**Comments on Response to Submissions: State Significant Development Application  
No.200 Aldington Road Industrial Estate (SSD-10479)**

Thank you for the opportunity to provide feedback from the Western Sydney Planning Partnership (the Partnership) on the updated response to submissions report and supporting information on the State Significant Development (SSD) application for the proposed at No.200 Aldington Road Industrial Estate (SSD-10479) on land at No.106-228 Aldington Road, Kems Creek NSW 2178 (Lots 30-32 in DP 258949 and Lots 20-23 in DP 255560).

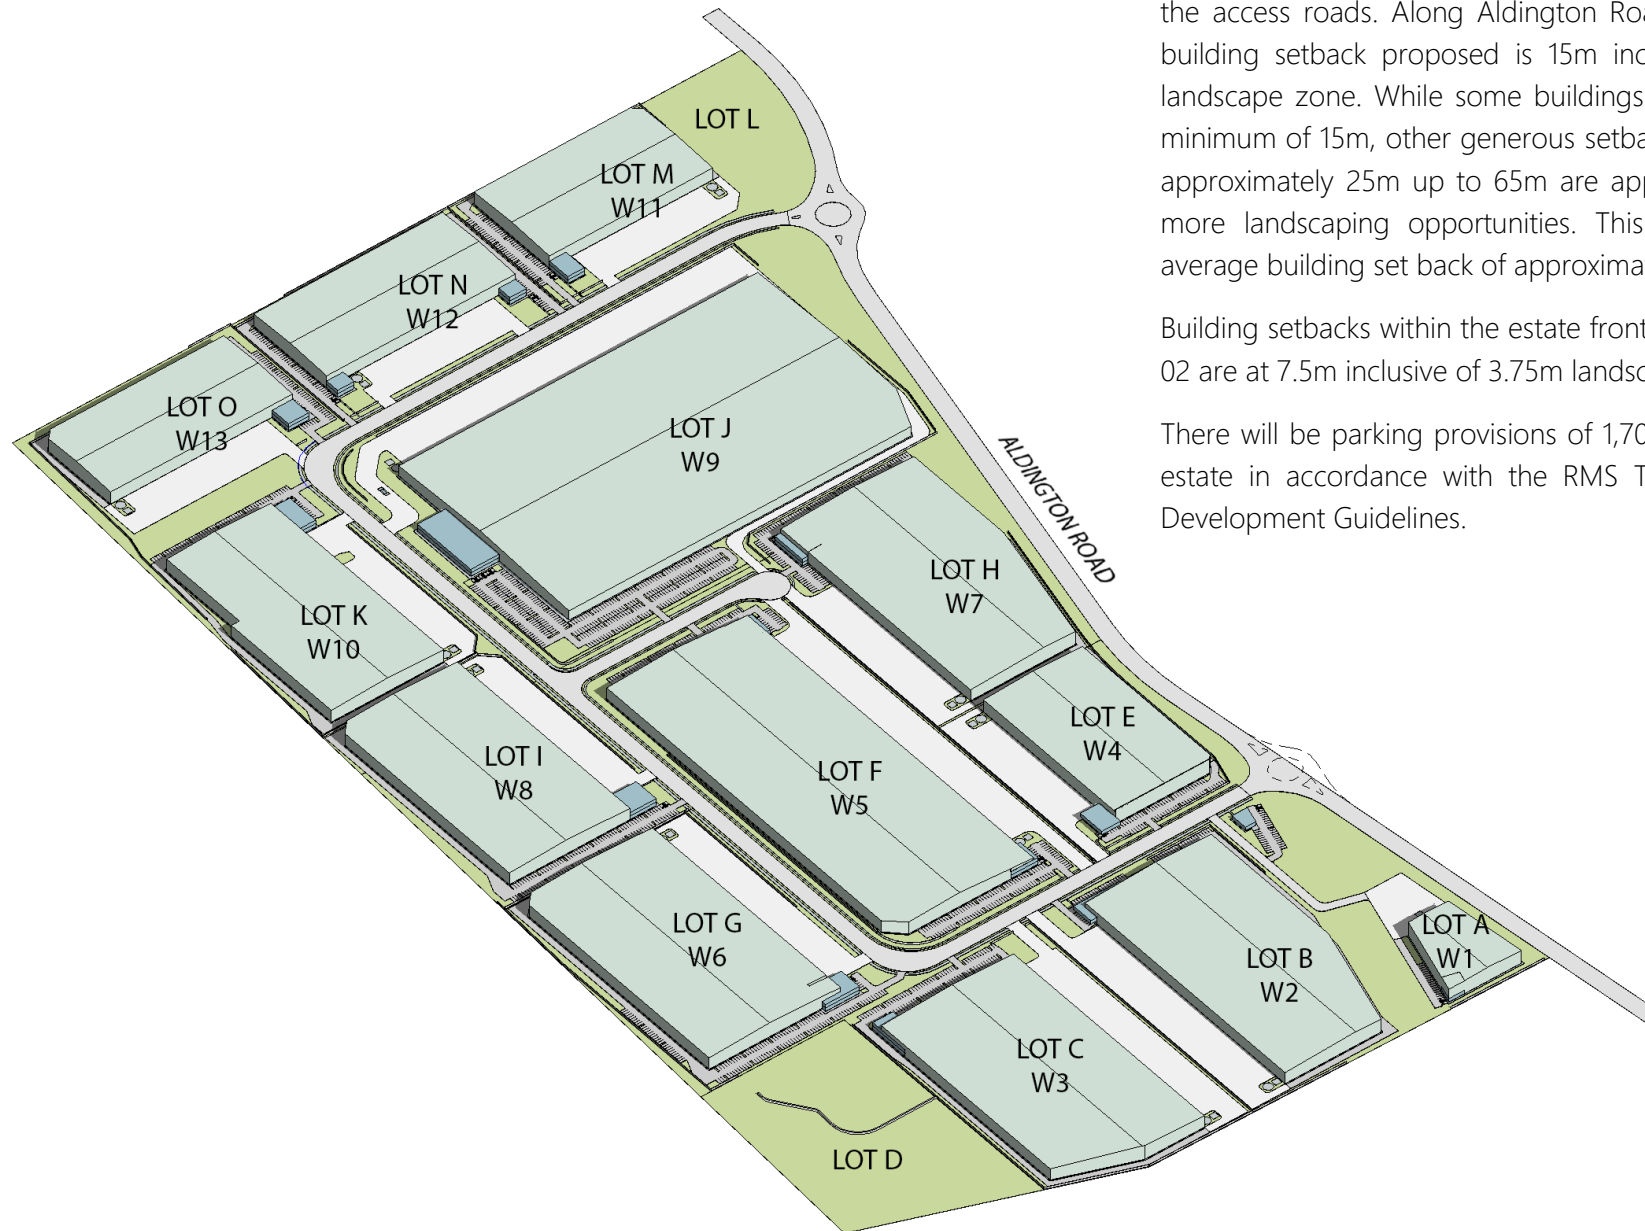
The proponent has previously responded to comments for the proposed SSD application to take into consideration the Aerotropolis planning principles contained in the Appendix (pages 92-94). Nevertheless, objective SU4 – ‘Orient urban development towards creeks and integrate into the landscape through quality open space, a high degree of solar access and tree canopy’, it is seen more could be done to creating usable quality open space for future workers whilst achieving environmental outcomes and mitigating flood impacts.

Therefore, a greater focus of this RE2 zoned land should be for recreational purposes which should allow accessibility for workers. There should be further examination on how this land can achieve recreational spaces whilst also achieving environmental outcomes and mitigating flood impacts. It should be noted that due to the proposed building floorplates and hardstand areas, there will be limited opportunities for open space areas within lots as shown on the revised concept masterplan unless roofed areas can provide this space.
